MECKLENBURG COUNTY
Park and Recreation Department

MEMORANDUM

DATE: February 20, 2008

RE: Rezoning Petition # 2008-053 Whitehall Corporate Center (overland connector)

ARROWOOD ROAD  
F - F' Cross-Section

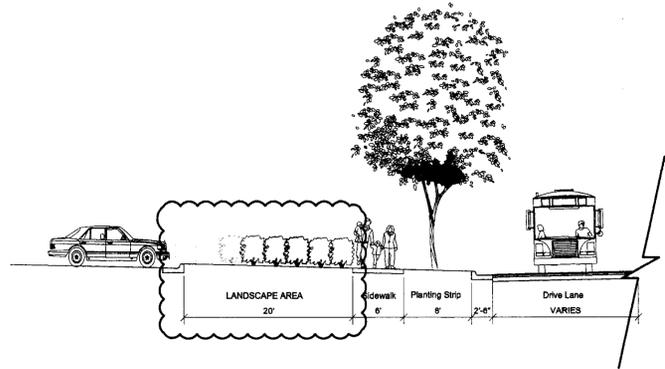
- MCPR requests that the petitioner provide a minimum 8' wide planting strip and 8' wide sidewalks along Arrowood Road.
- MCPR will continue to work with CDOT to refine this request.
